## KEMPS CREEK ESTATE – SSD-9522 MOD 3

### Response to Request to Additional Information (2)

TUNRING PATHS PLAN-TURNING HEAD
SCALE 1:300

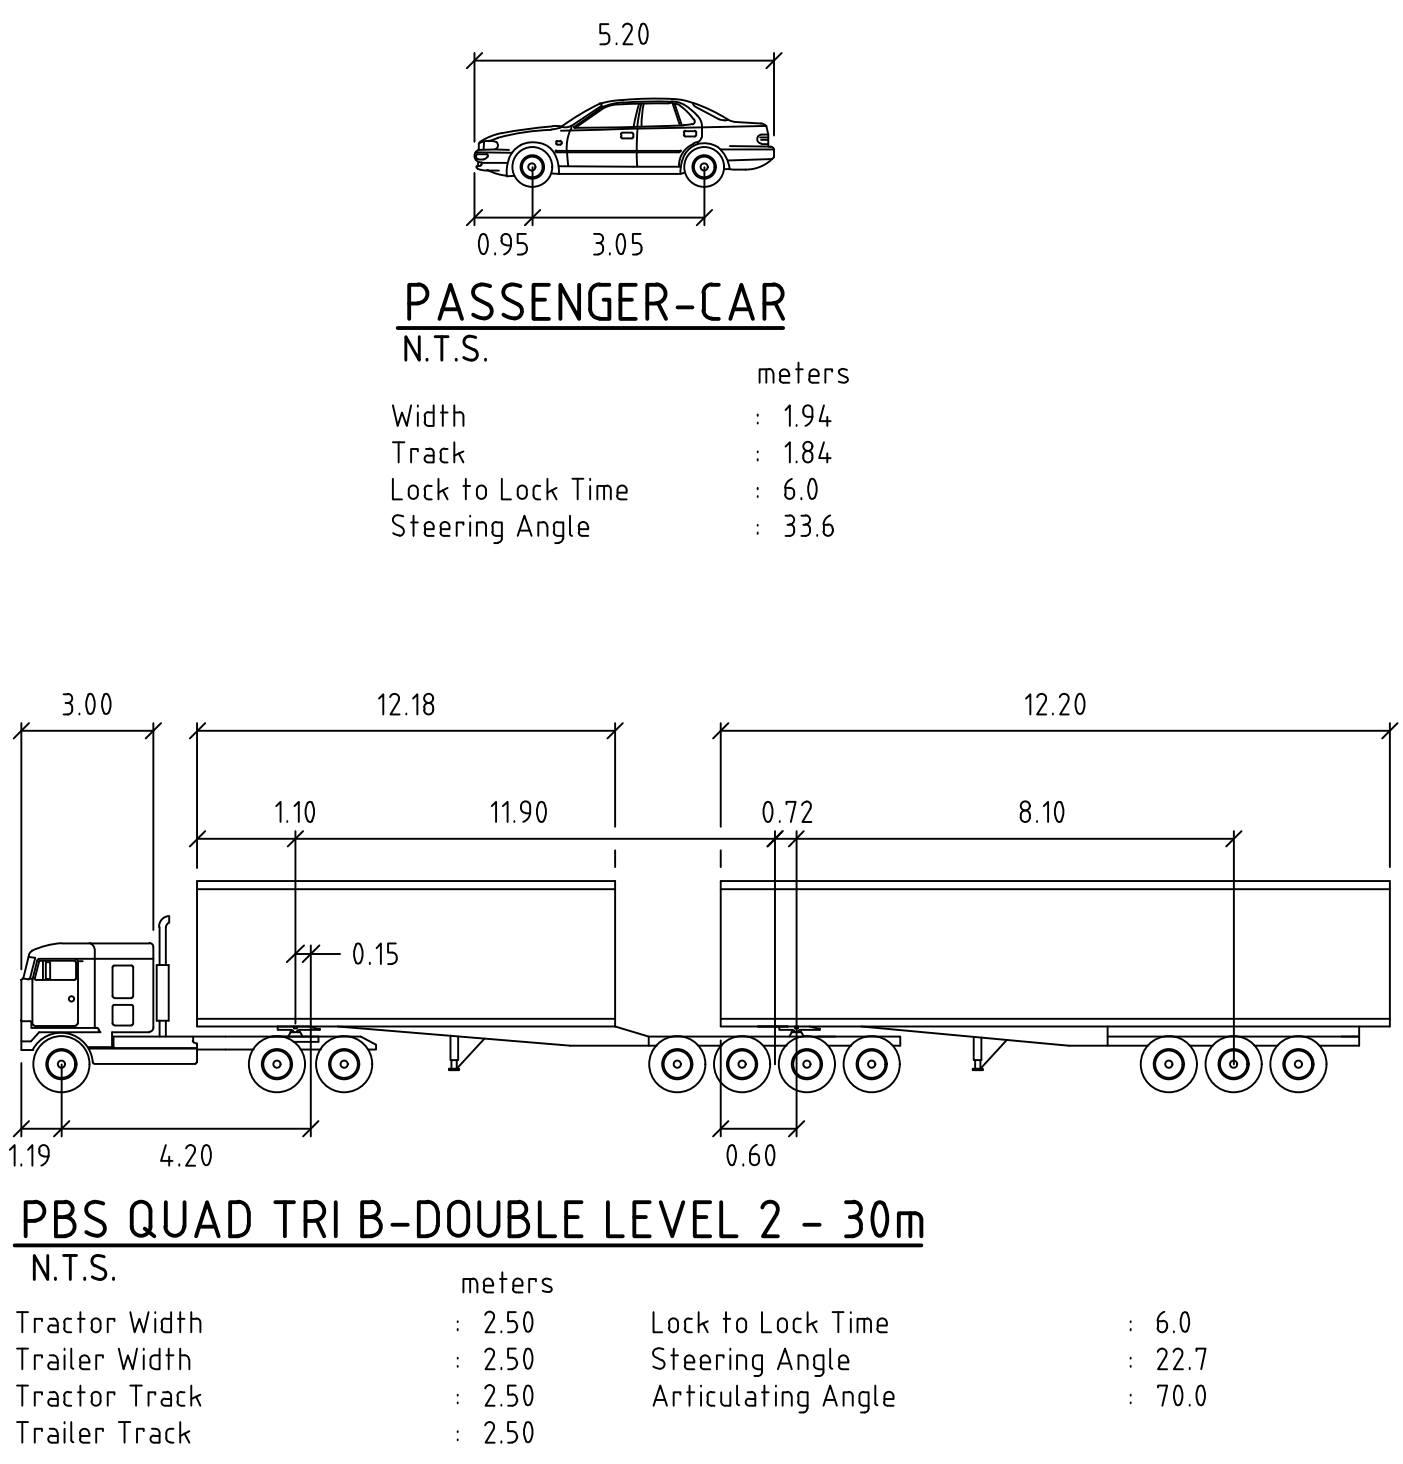
<p>In its previous submission Council's traffic engineers raised:</p> <p><i>'Council recommends that Lot 3 truck swept paths (Sheet AG15) are to be modified to show that a truck can turn around while there are parked trucks'.</i></p> <p>The applicant states that truck will be side loaded and thus no manoeuvring area is required. It is raised that the site will be utilised by numerous tenants over the life of the development and that adequate truck turning facility is to be demonstrated for worker safety and futureproofing reasons.</p>	<p>This swept path analysis is provided again in below to provide context for the Ason response:</p>  <p>(Refer SHEER AG15)</p> <p>It is noted that the articulated vehicles can reverse into all RSDs as shown in AG16. 30m Super B-Double / and 26m B-Double access to this site shall be undertaken via side loading and shall be managed through future operational management plans regardless of type of tenancy which enter that site. This means, the future</p>	<p><b>Appendix C</b> in the Amended Development Report</p>

<p>The Department will need to be satisfied that truck turning whilst parking bays are in use is not accommodated.</p>	<p>tenant's will have to ensure that prior to attendance of any B-Doubles to Lot 3, all those RSDs are unoccupied so that this full U-Turn as necessary be completed and B-Double exits the site in forward motion as shown above. Even during this period, and as shown above, there will be 2 recessed docks available for future tenancies to provide access for articulated vehicles noting that the recessed docks would not be impacted by B-Doubles manoeuvres on site.</p> <p>Our experience with similar warehouse DAs suggests that such small scale tenancies (lot 3) are unlikely to generate significant B-Double movements and therefore, the B-Double attendance on this site would be quite infrequent.</p>	
<p>In its previous submission, Council had raised that:</p> <p>'According to Table 19 of the Transport Assessment report, Lots 1 – 4 will be accessed by trucks up to 26m B-double. However, the swept paths presented in Appendix D only used 20m semi-trailers to demonstrate the movements in and out of the truck bays.</p> <p><i>The Department is advised to seek clarification on this inconsistency and ensure coordinated reports demonstrate compliance with the required access provisions for the Precinct'.</i></p> <p>The applicant has not responded to this matter and the Department is advised to seek resolution as part of its assessment. This issue is not resolved.</p>	<p>Reference has been made to Appendix D of our traffic report which shows B-Double swept paths for all warehouses with the details below.</p> <p>It is noted that the buildings on Lot 1 and 4 have been removed as part of the amended design and comments related to these buildings are no longer applicable</p> <ul style="list-style-type: none"> <li>- Lot 2 – Refer SHEET AG11. Side loading of a 30m Super B-Double has been shown. B-Doubles / Super B-Doubles are not intended to undertake reverse loading activities on the site hence, we have shown RSDs for reverse movements up to articulated vehicles and for Super B-Doubles we have shown side loading in SHEET AG11.</li> </ul> <p>Site-specific OTMPs expected to follow the SSD approval can manage truck movements in each warehouse.</p> <ul style="list-style-type: none"> <li>- Lot 3 – Refer SHEET AG15. Side loading of a 30m Super B-Double has been shown. B-Doubles / Super B-Doubles are not intended to undertake reverse loading activities on the site hence, we have shown RSDs for reverse movements up to articulated vehicles and for B-Doubles we have shown side loading in SHEET AG15.</li> </ul> <p>Lot 3 is a smaller scale warehouse, although it is yet a speculative warehouse, we assume</p>	<p><b>Appendix C</b> in the Amended Development Report</p>

Figure 1: Site Plan

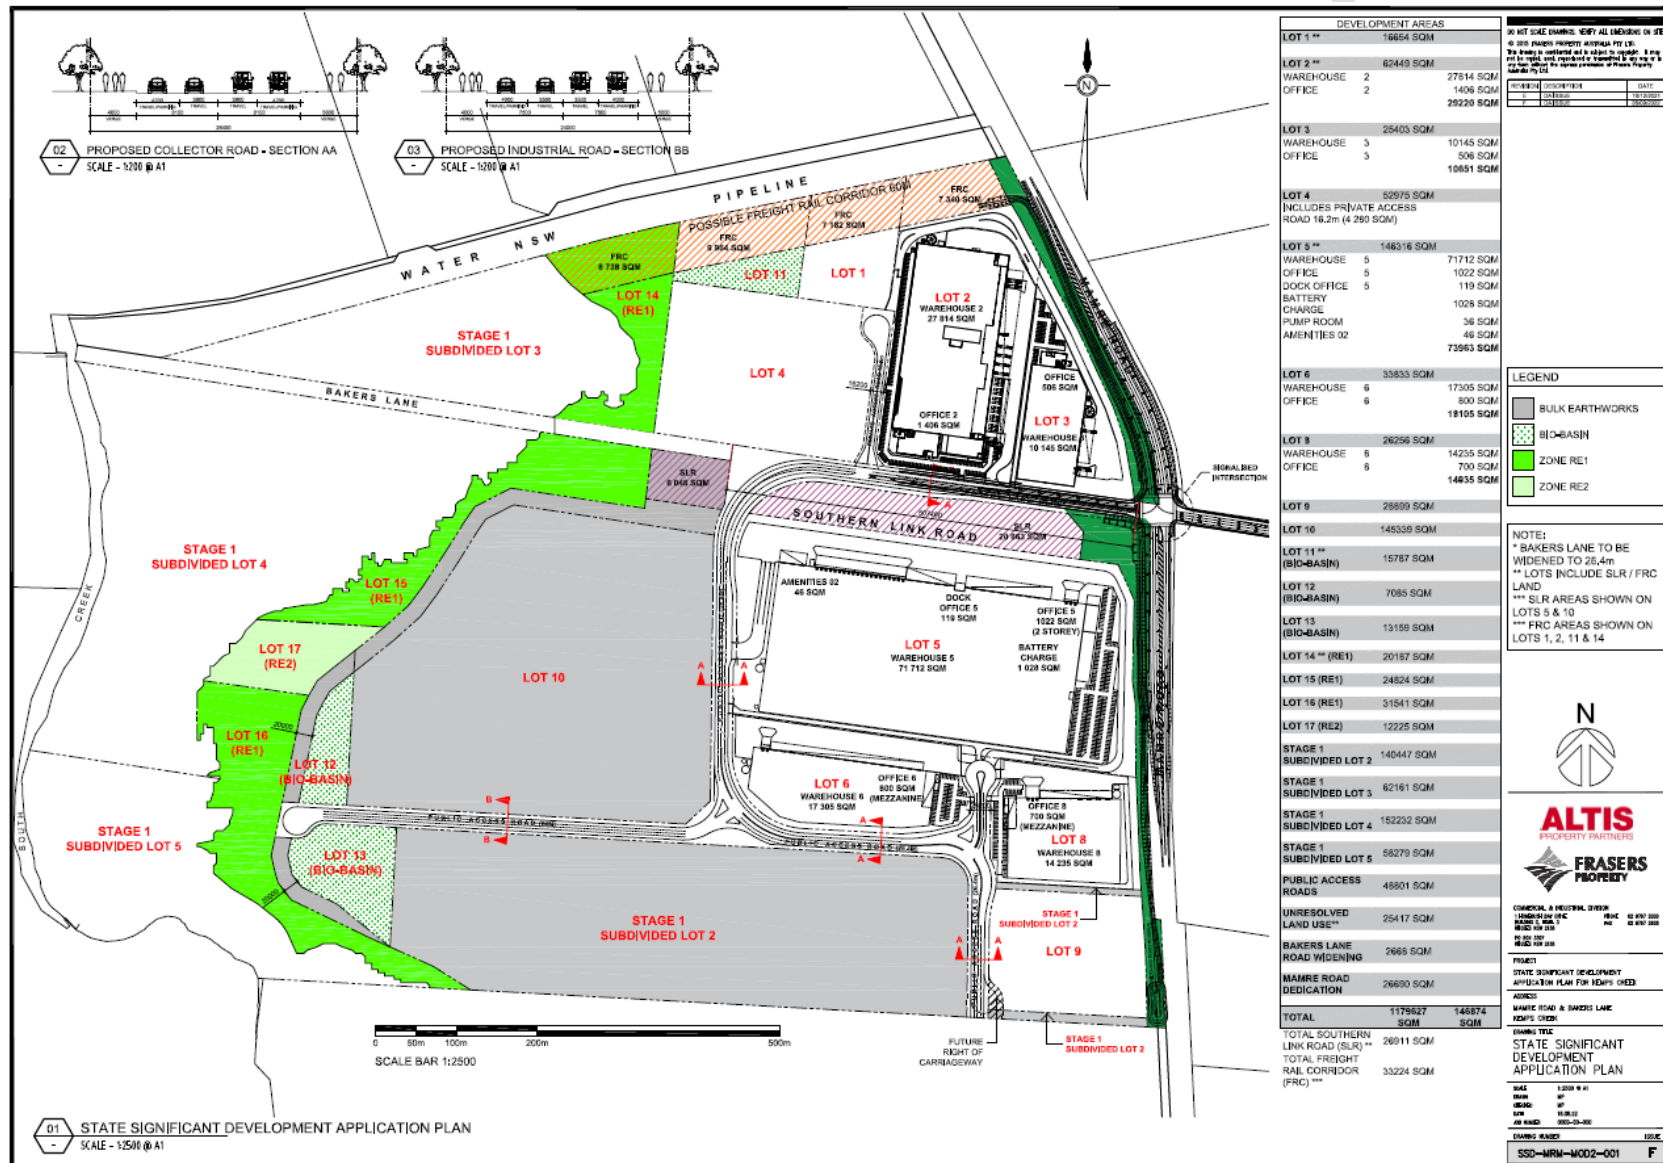
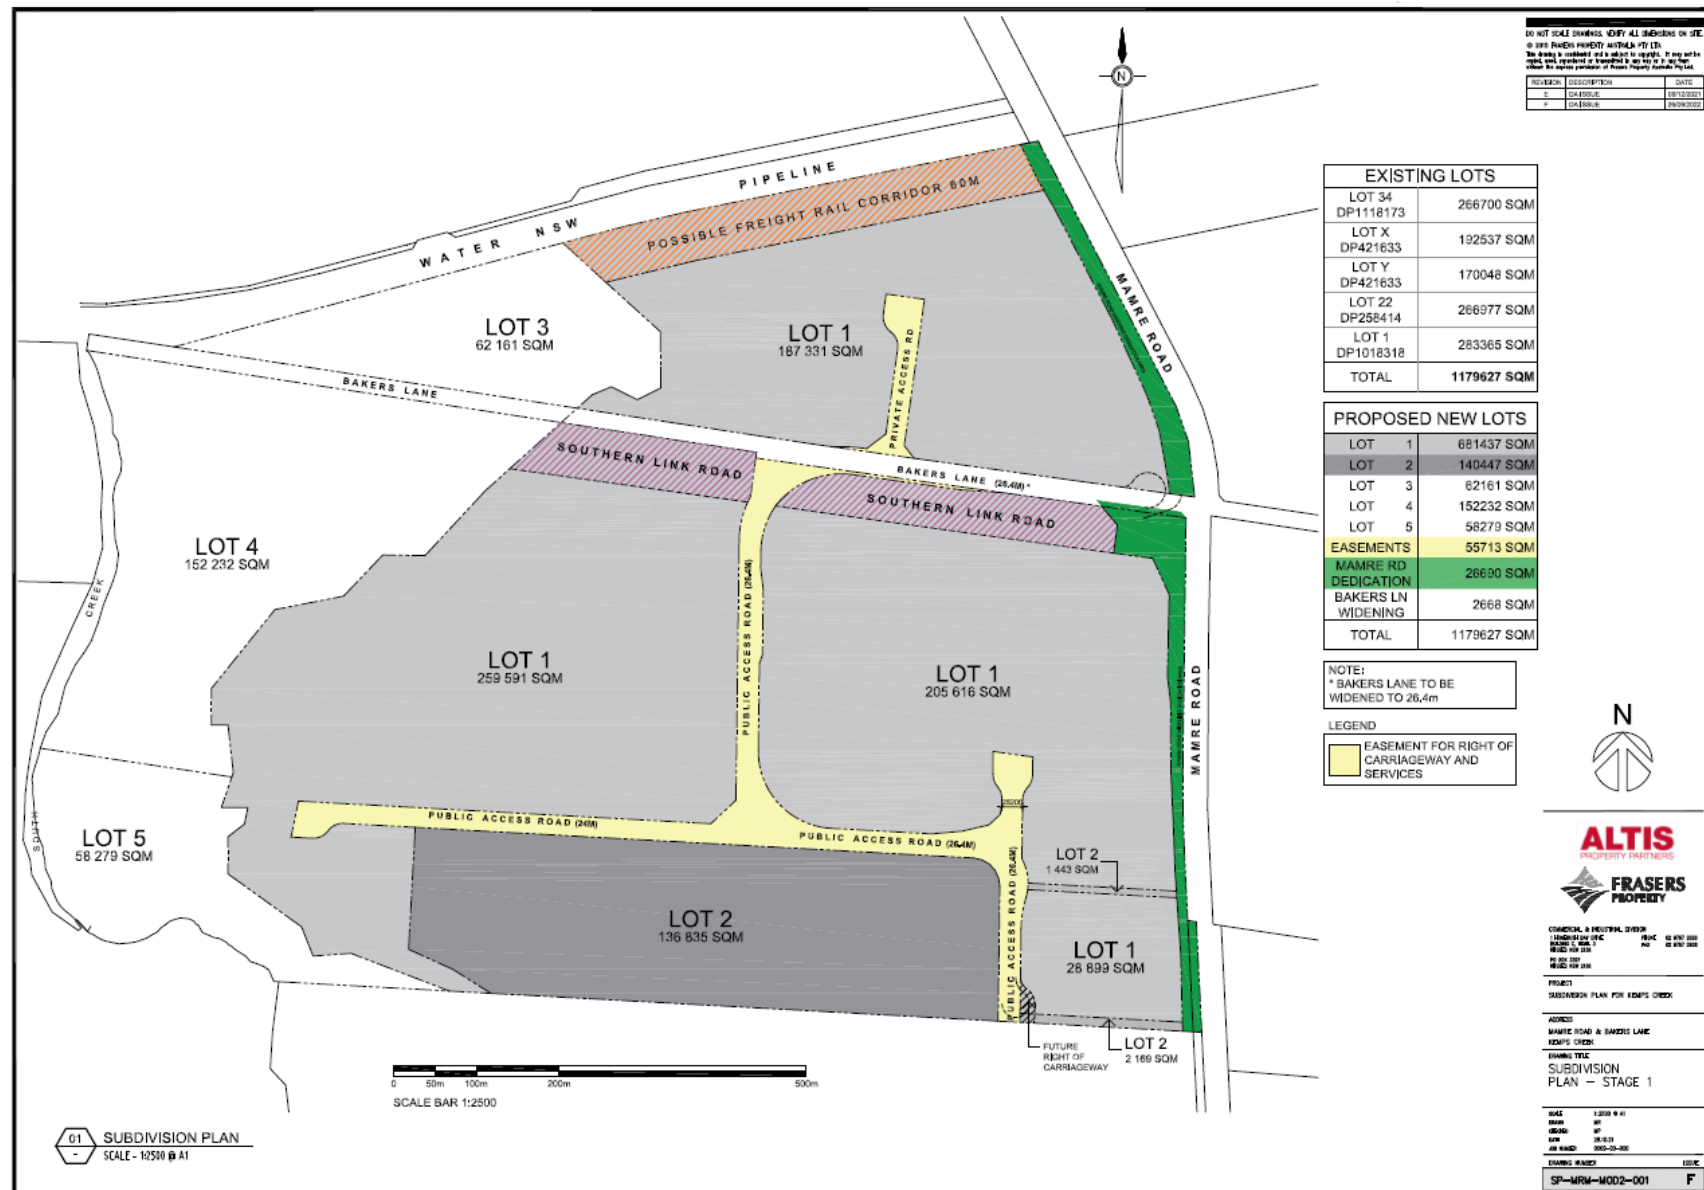
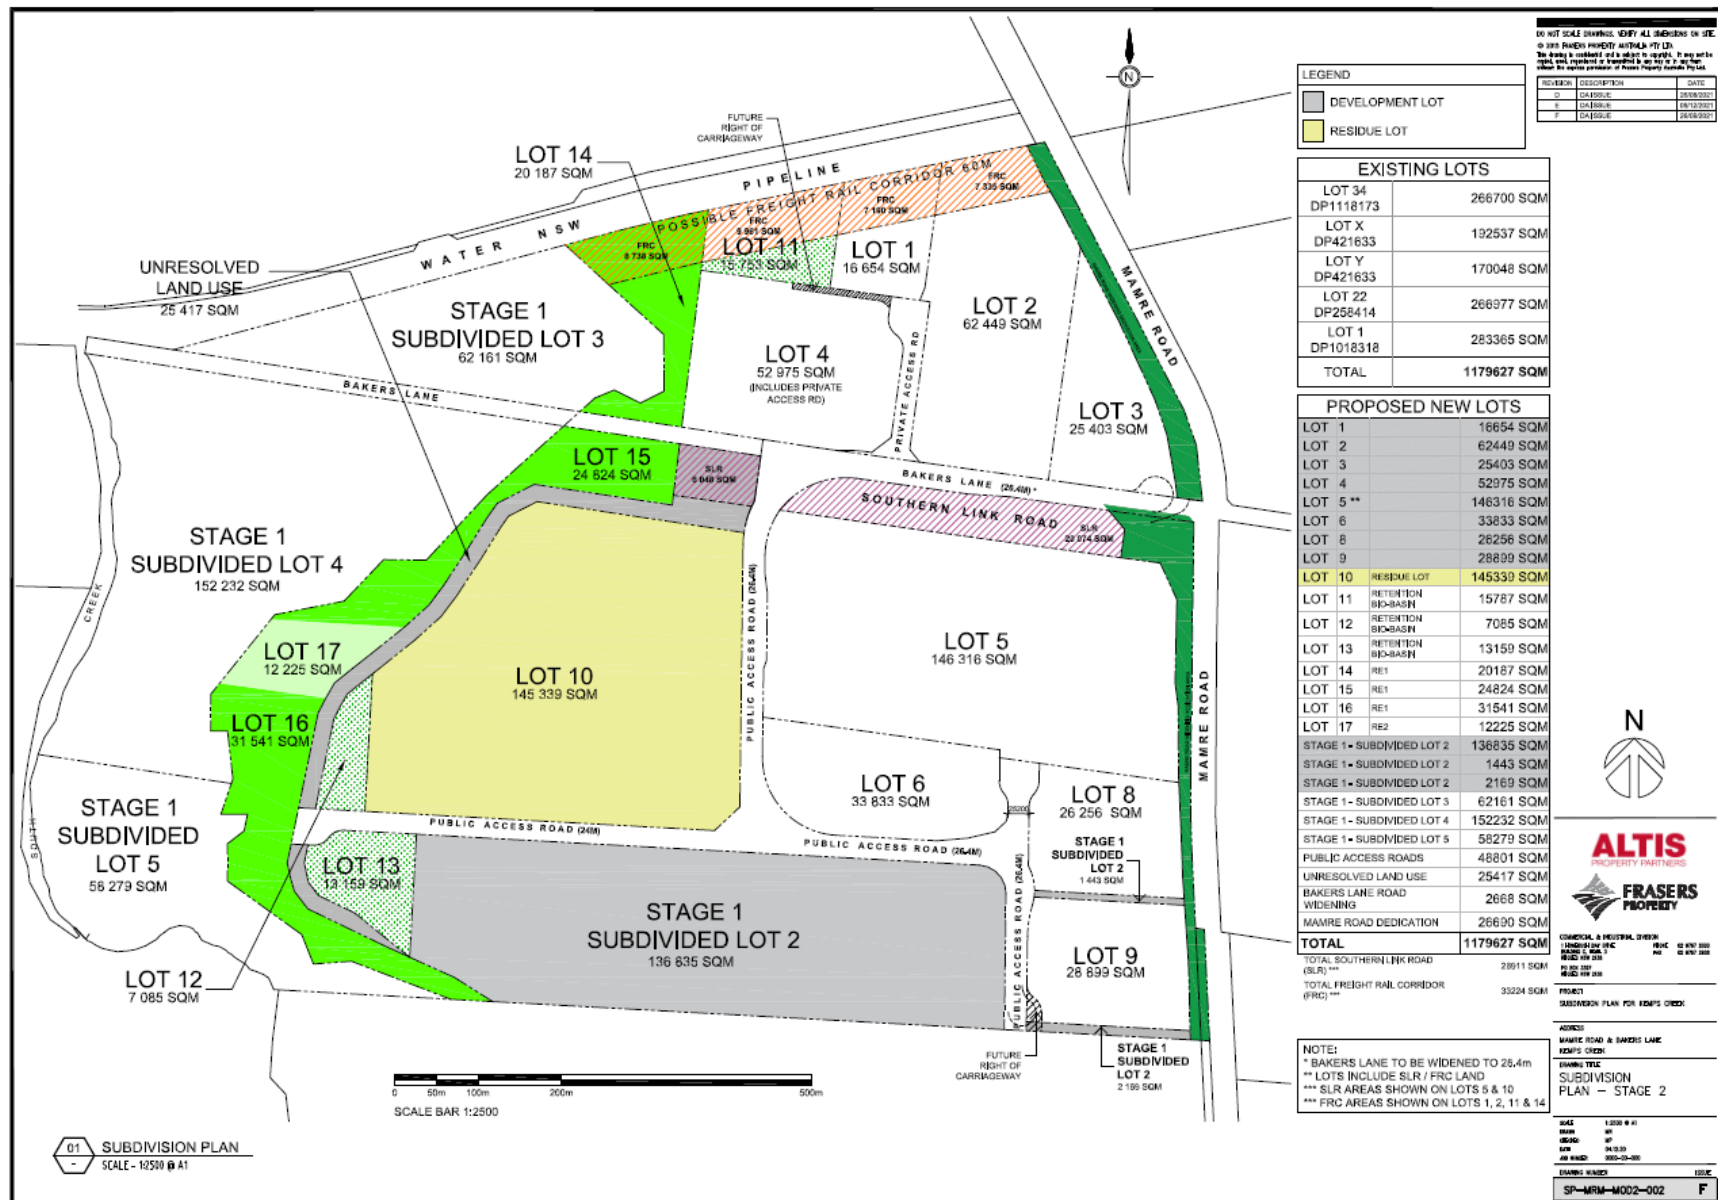
Comment	Response	Section
As requested previously, please provide updated versions of the site and subdivision plans at Appendix 1 of the consent for SSD-9522 that reflect the modified site layout.	<p>The updated versions of the site layout plan and subdivision plans have been provided at <b>Appendix A</b> of the Amended Development Report.</p> <p>A Section 37 Request to Amend SSD-9522 MOD 3 has been submitted to DPE.</p> <p>The amendment to SSD-9522 MOD 3 is for the withdrawal of Lots 1 and 4 from the application, with only Lots 2 and 3 and the associated works for warehouses 2 and warehouse 3 to remain. The amendment also includes the removal of the access road off Bakers Lane.</p>	<p><b>Section 3</b> of Amended Development Report</p> <p><b>Appendix A</b> in the Amended Development Report</p>
The Department notes that it is no longer proposed to delete or modify Condition B4 under this application. With regard to Condition B18, the Department still does not support the removal of this condition. Should the concept design required by Condition B18 meet the requirements of TfNSW, the Department can provide a separate letter advising that the condition has been satisfied in accordance with standard practice for post-approval matters.	The Proponent accepts this arrangement.	N/A
